Application Ref:	3/2025/0793			 Ribble Valley Borough Council www.ribblevalley.gov.uk
Date Inspected:	23/10/2025	Site Notice:	N/A	
Officer:	EP			
DELEGATED ITEM FILE REPORT:				
				APPROVAL

Development Description:	Proposed demolition of existing rear conservatory and construction of single-storey rear extension and new front porch. Addition of new render and composite boarding to external elevations and proposed new roof to existing garage.
Site Address/Location:	11 Whittam Crescent, Whalley, BB7 9SD.

SHEET:
PROPOSED FLOOR PLAN

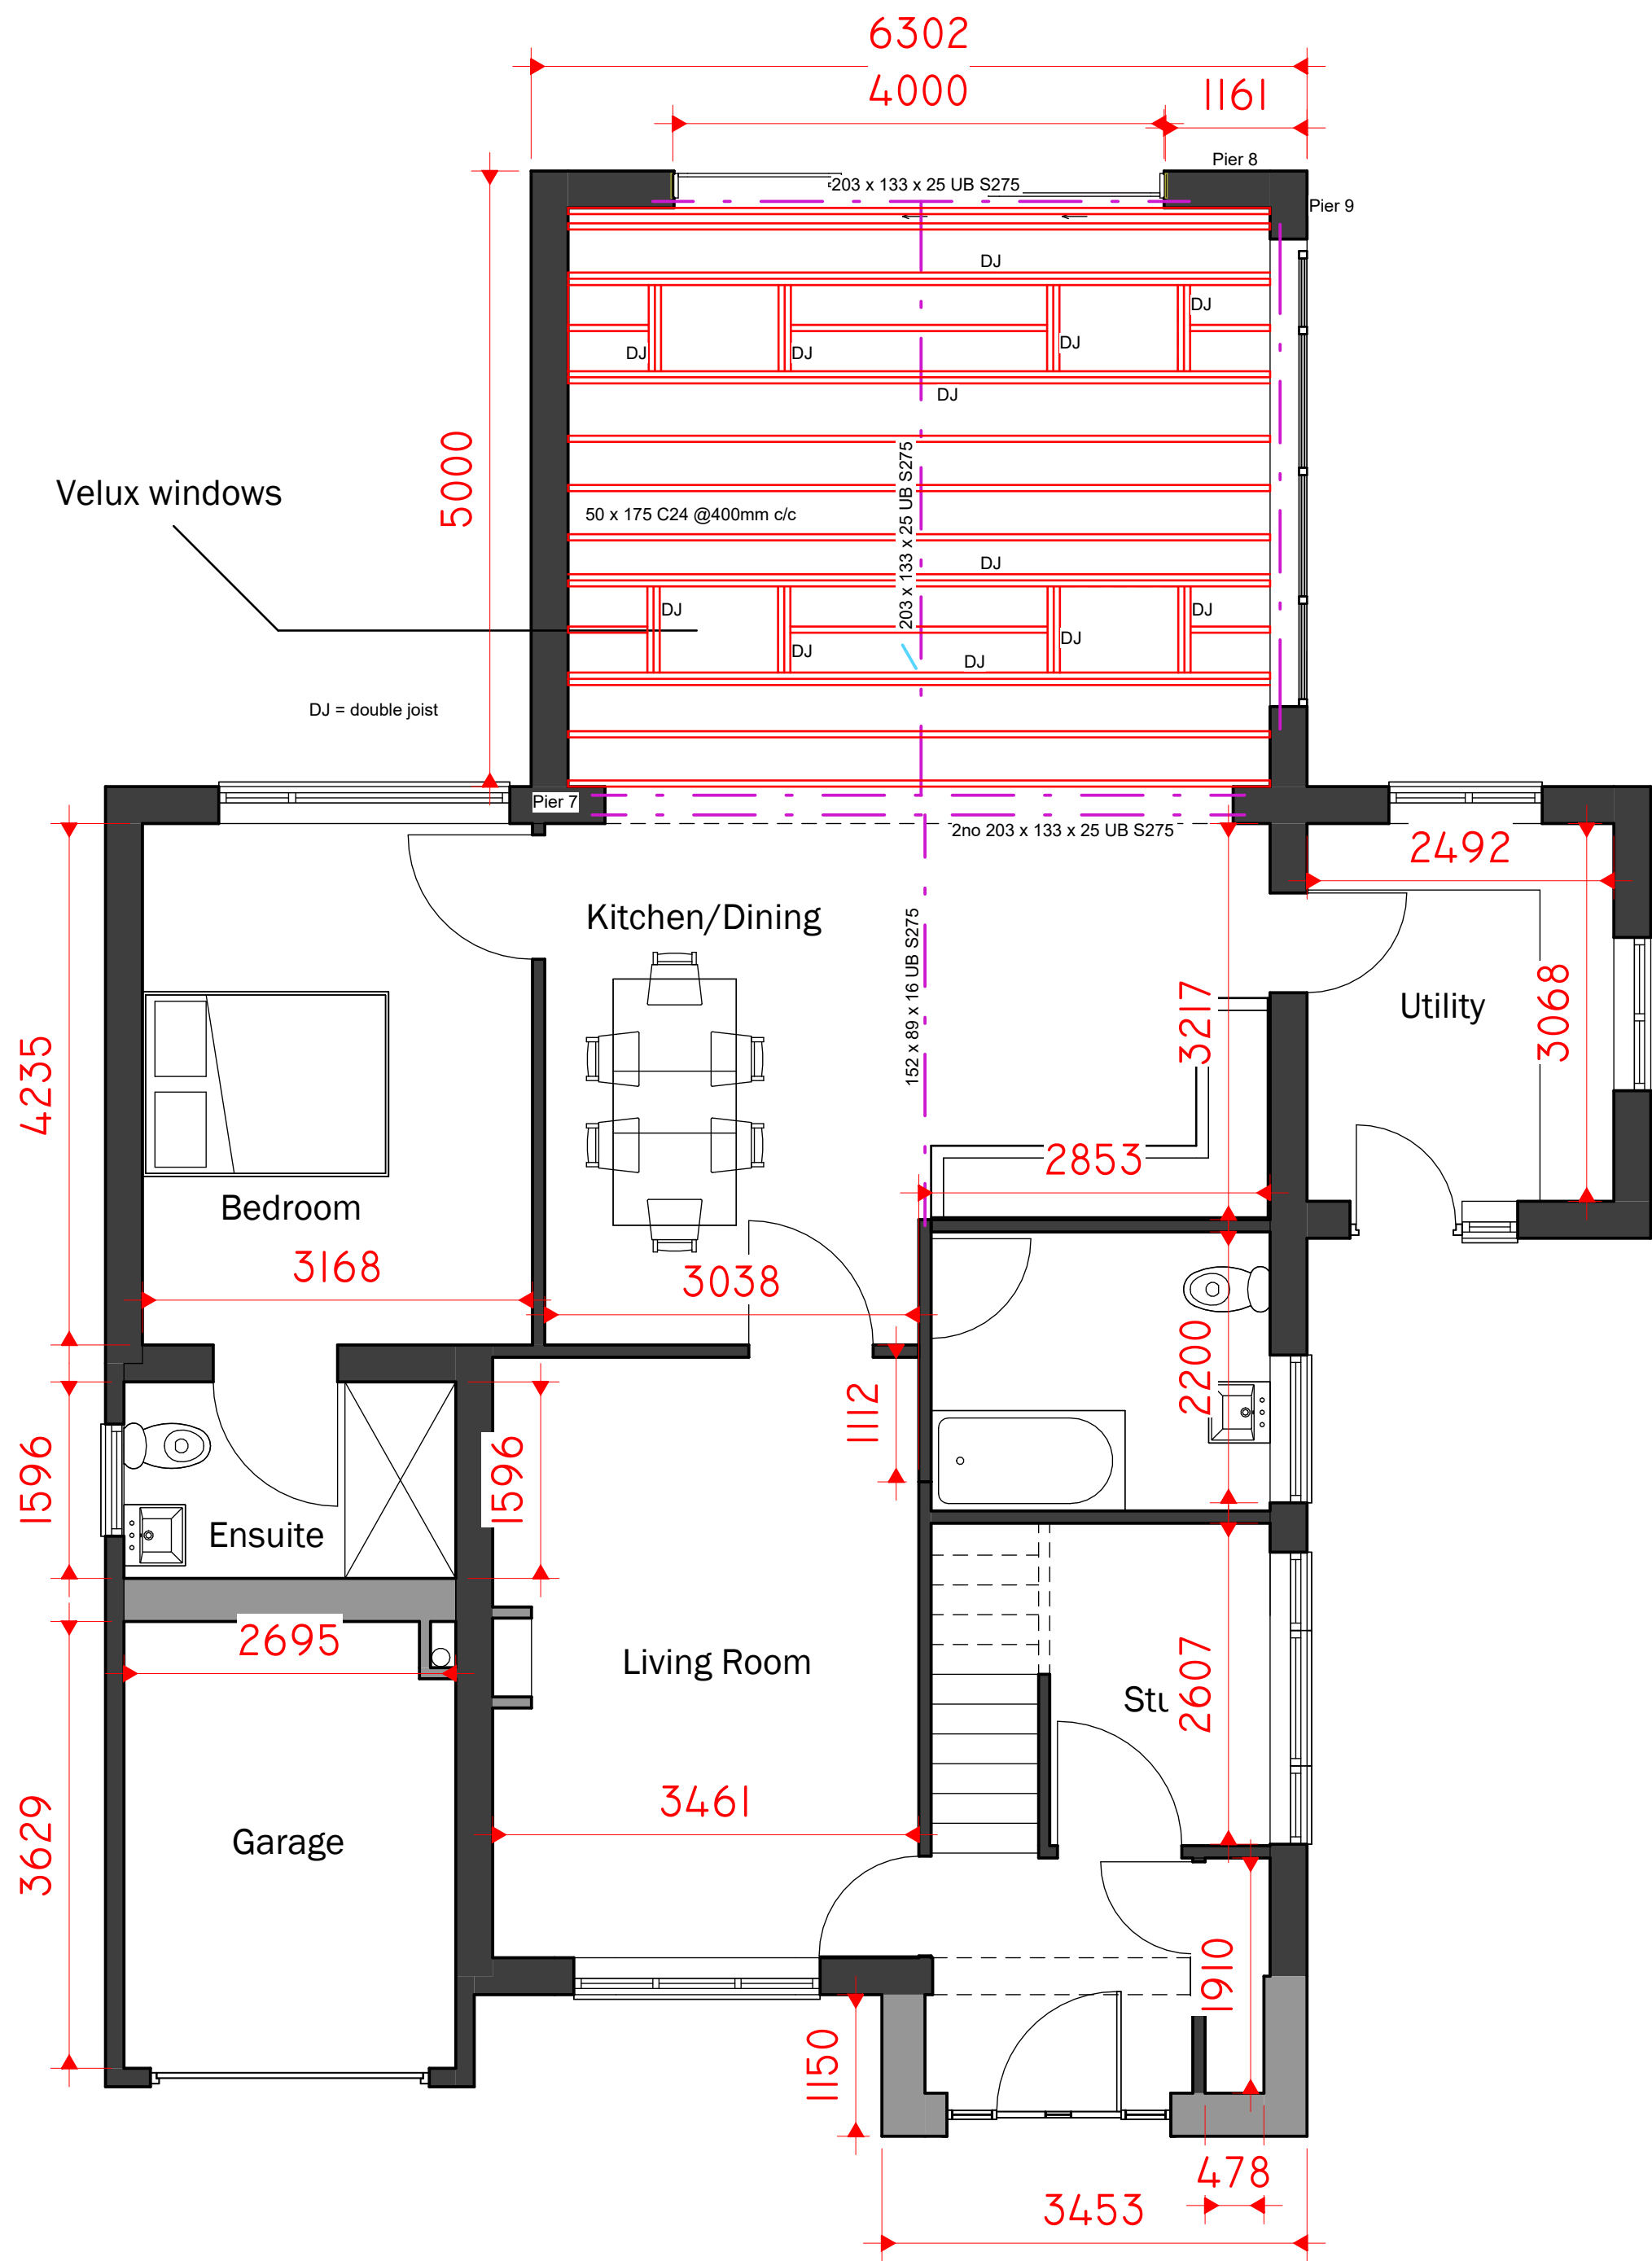
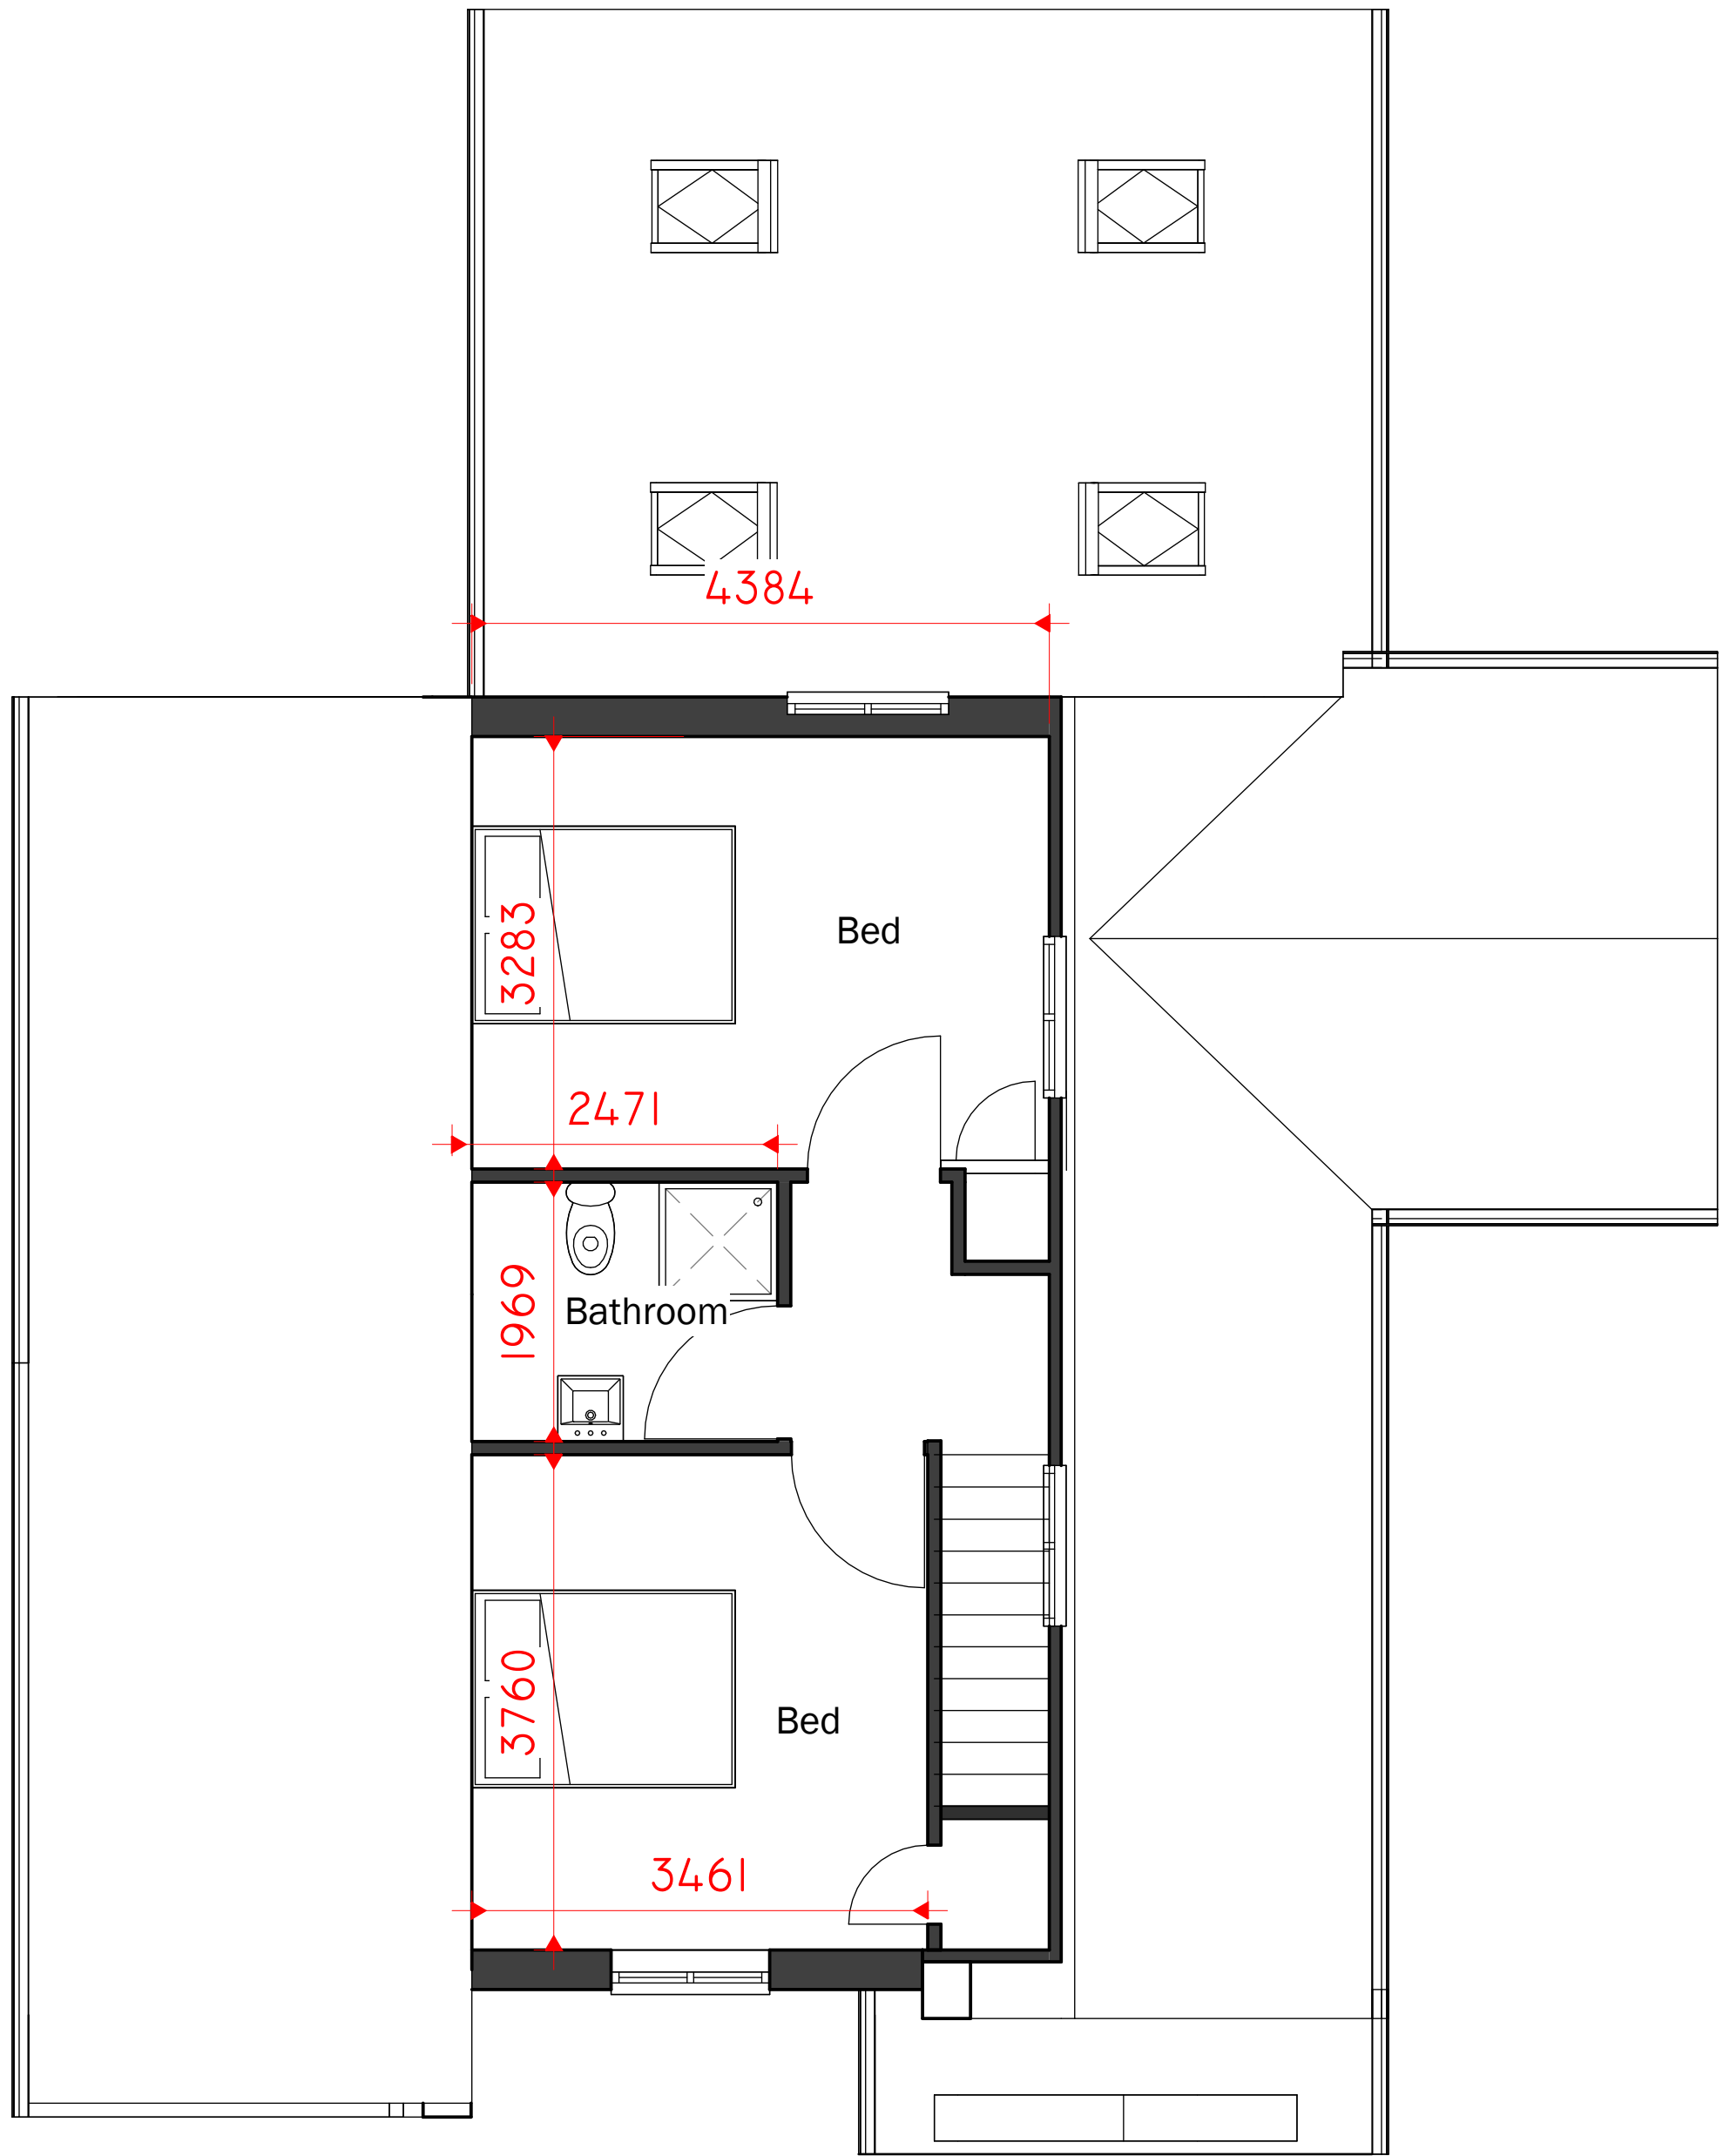
It is also not considered that the proposed re-modelling works would result in any significant undue harm upon any neighbouring residents by way of overshadowing, loss of outlook or daylight. The proposed front porch would remain approximately 5m from no.13 Whittam Crescent at its closest point and given the orientation of the application property in relation to this adjacent residential property and the relatively small-scale of the front porch, the proposed additions are not expected to result in any greater impact than that of the existing built form.

The proposed lean-to roof to the existing flat roof integral garage would also comprise a relatively minor addition to the application property and therefore would not result in any measurable adverse impact upon no.9 Whittam Crescent. The proposed rear extension would also comprise a rearward projection of 5m and would be adequately distanced from both nos. 9 and 13 Whittam Crescent so as to mitigate any resultant impact.
